CITY OF ALBUQUERQUE

RE: **Taos II @ The Trails**
Grading and Drainage Plan & Report
Stamp Date 7-13-16 (File:C09D00G1)

Based upon the information provided in your submittal received 7-14-2016, the above referenced Grading and Drainage Plan & Report is approved for Preliminary Plat with the following conditions:

**TAOS II AT THE TRAILS**  
**GRADING PLAN**

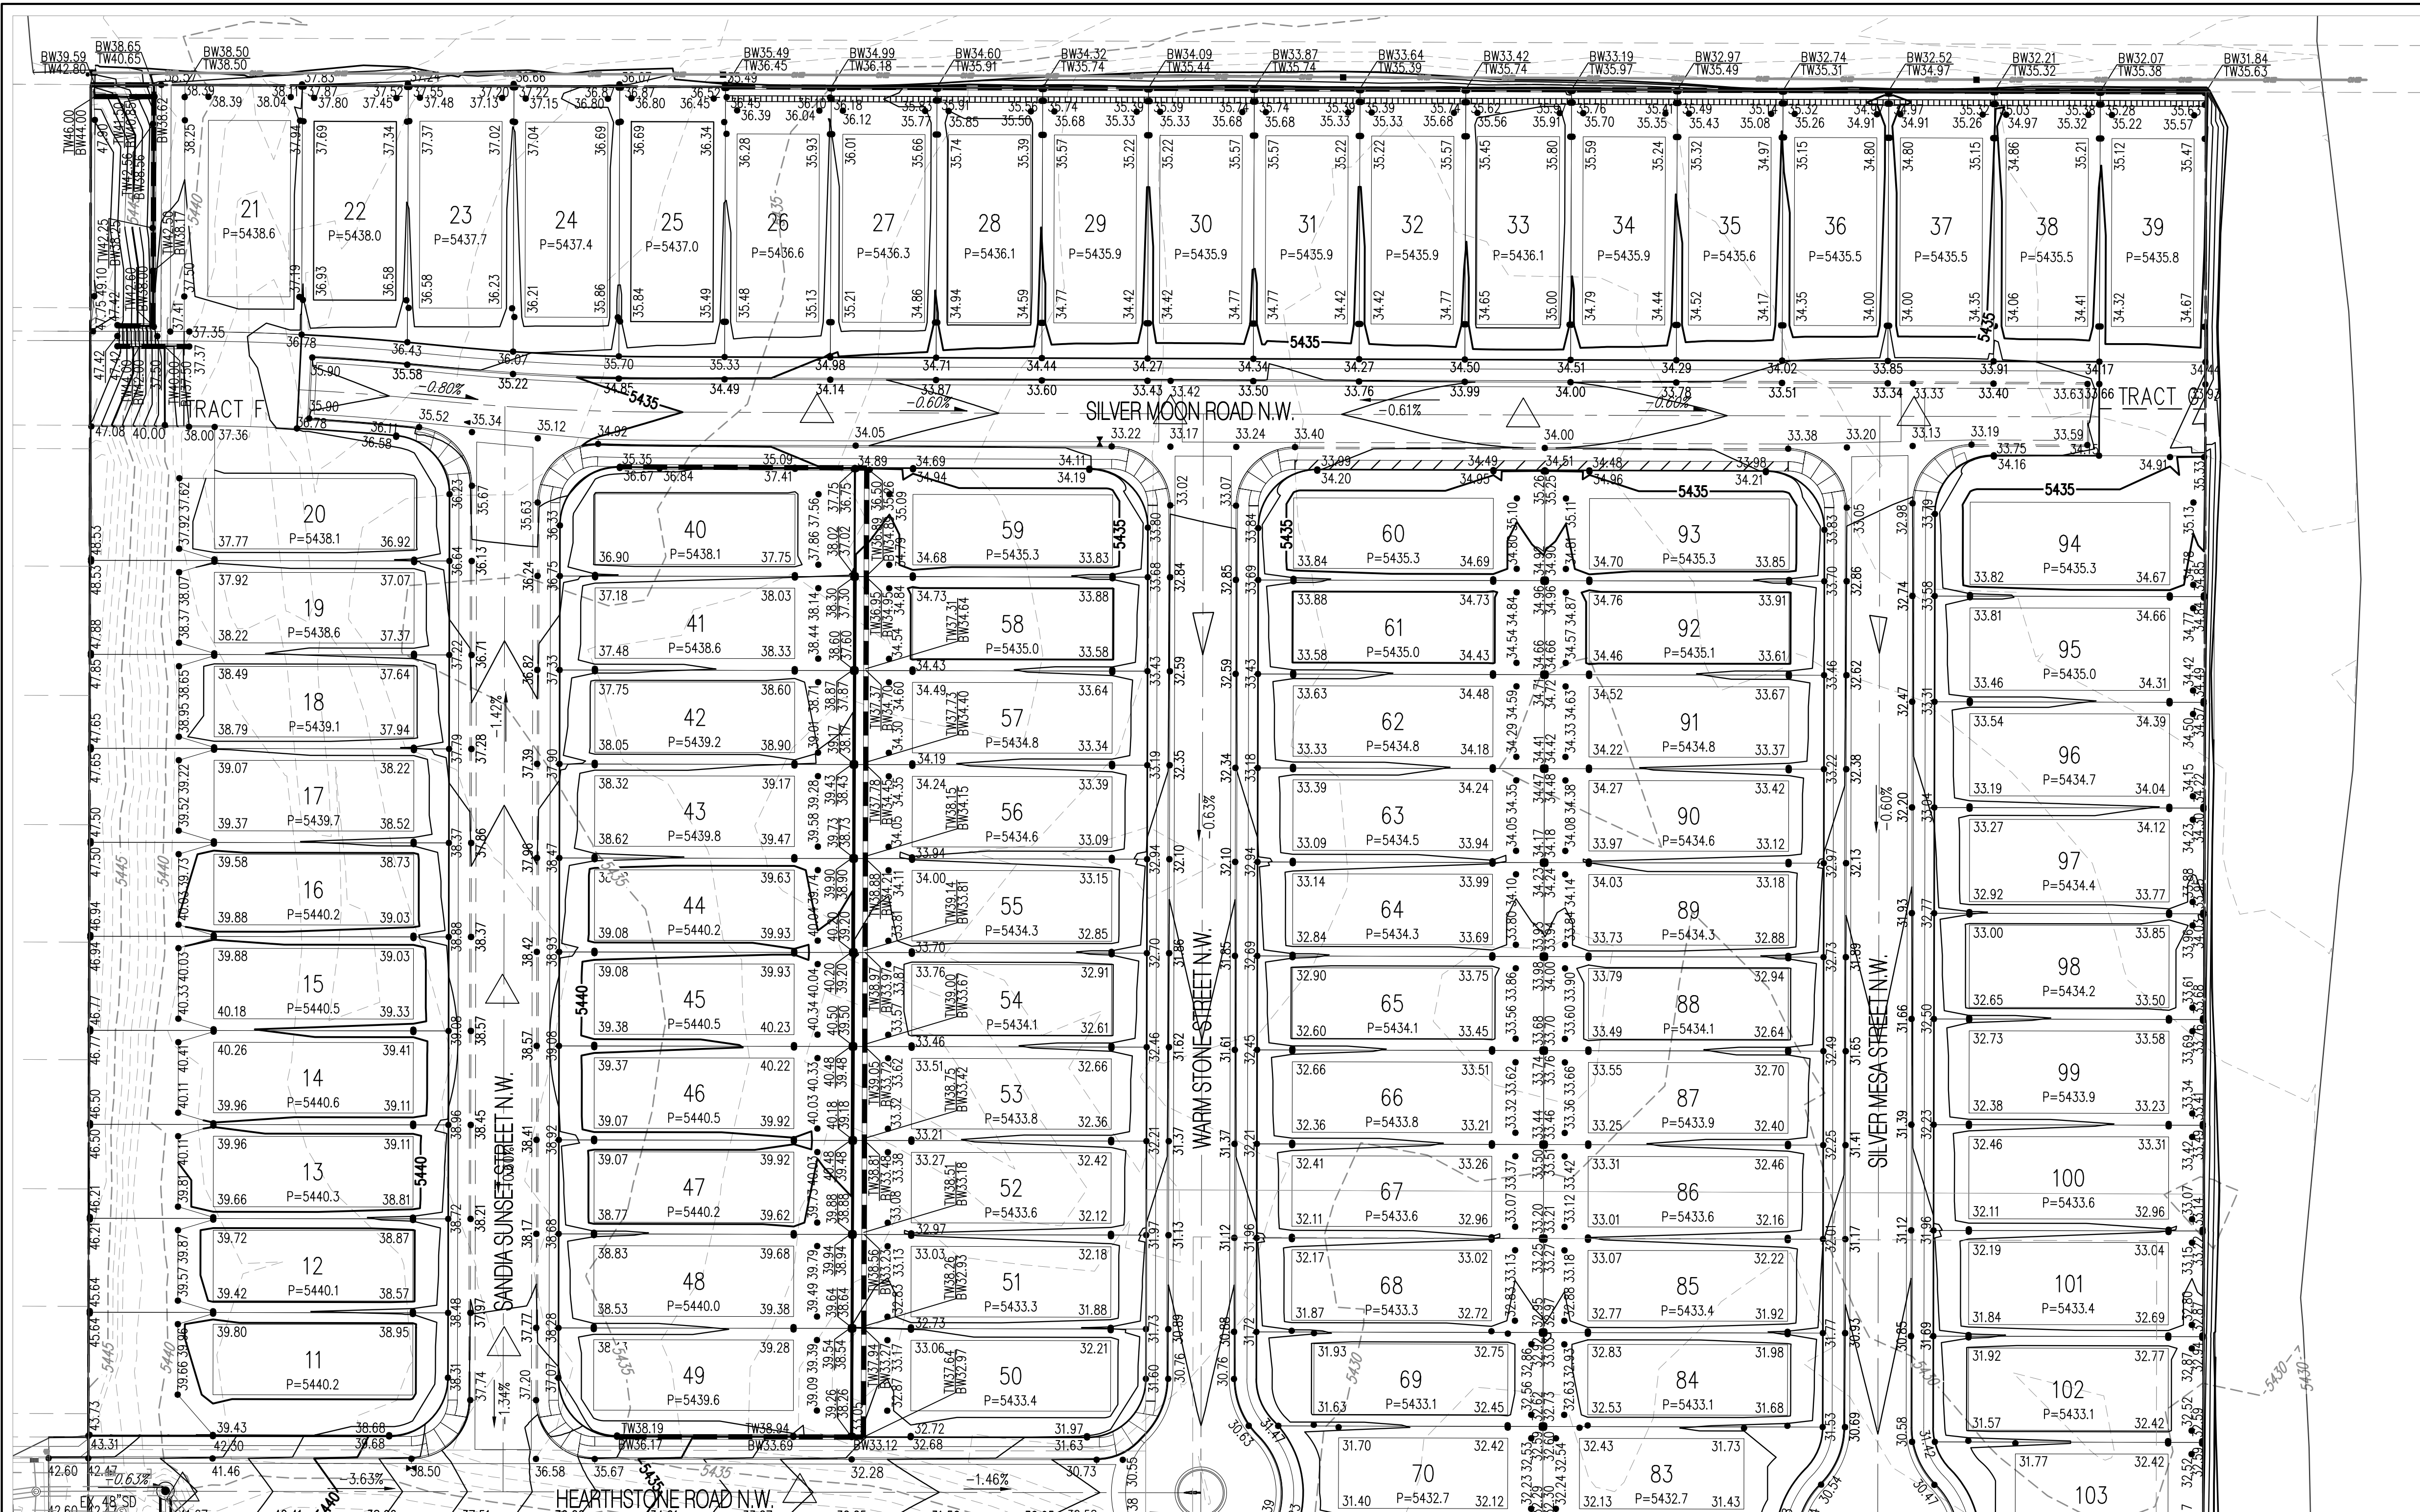
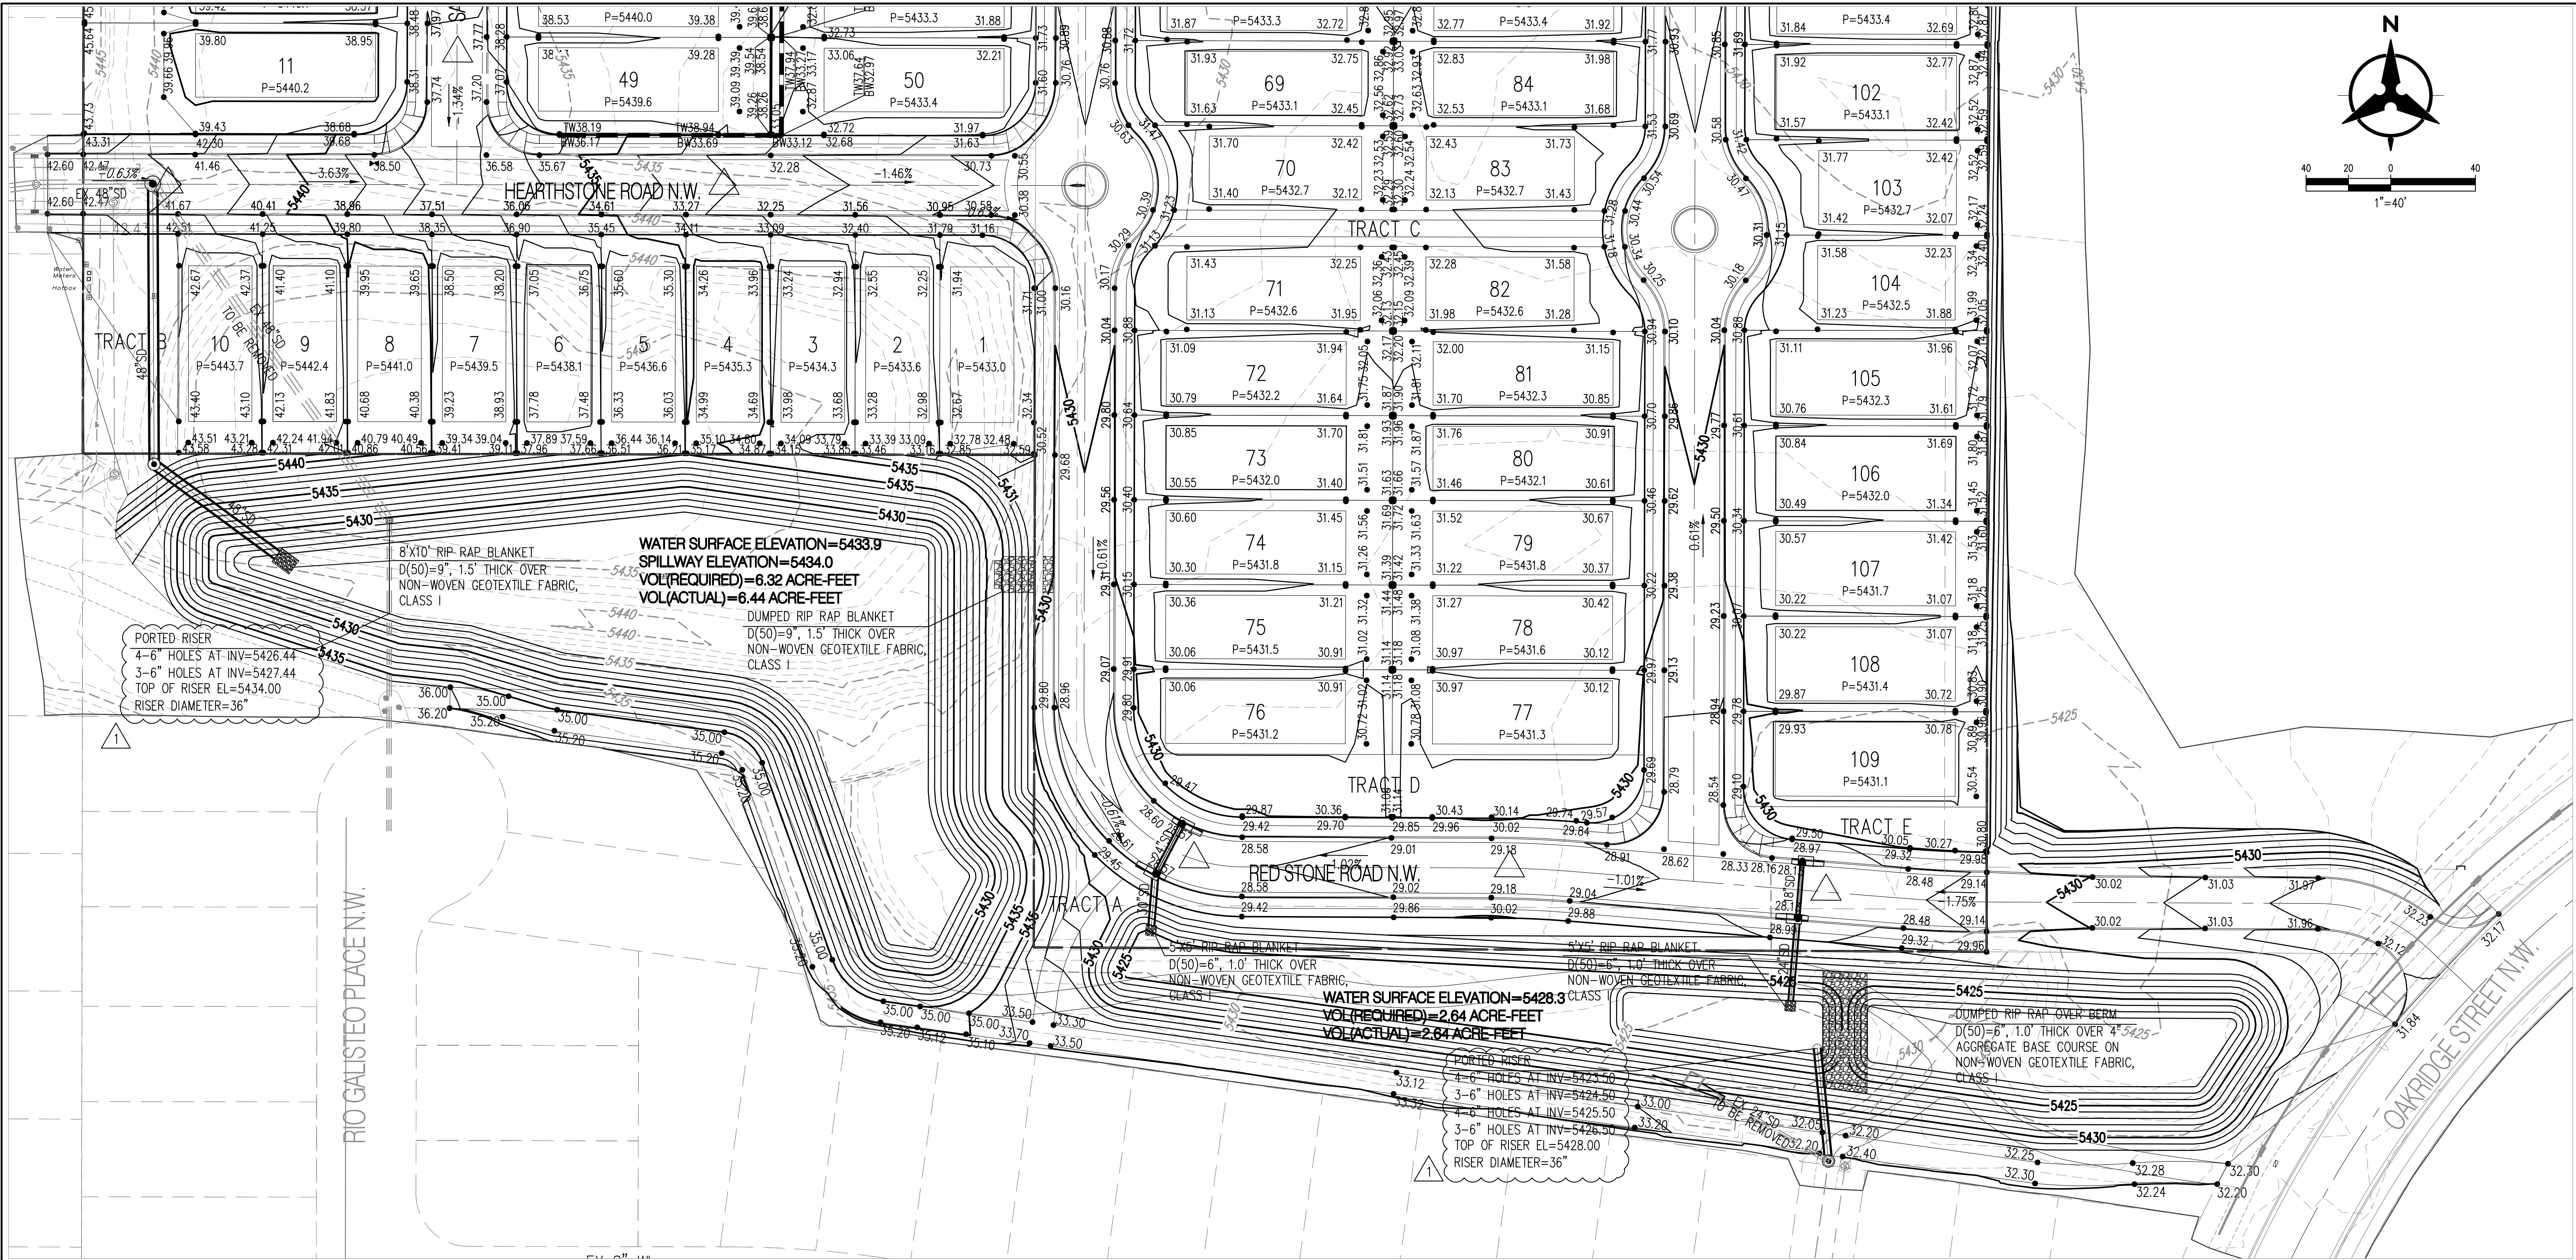
1. The Work Order Set will need to include sufficient survey information to show that the tie in to the existing Hearthstone Roadway section is completed with a smooth transition.
2. If the project is phased, the Work Order Set will be expected to include temporary/desiltation ponds where needed.
3. Forward a copy of any correspondence related to the permission for grading that will be needed for the perched access road from Oakridge St. on the adjacent property prior to Hydrology's sign off of the DRC Set.
4. The DRC Set will need to include enough survey information at the West end of Hearthstone to ensure that a smooth transition to the existing road.

2. The improvements referenced on the Infrastructure List need to be shown on the Grading Plan:
 - a. The Improvements related to Ponds F, F5 and D. The orifice plate can be included by reference or as a specific note/exhibit of the improvements required.
 - b. The outfall conditions into Pond F5. Note that the Drainage Master Plan elevations are based on NGVD 29 datum.
3. It is not clear where the wall drain detail will be used since it appears that all lots drain to the roadway. Any planned rear-lot ponding would require an easement.
4. An approved ESC Plan will be required.
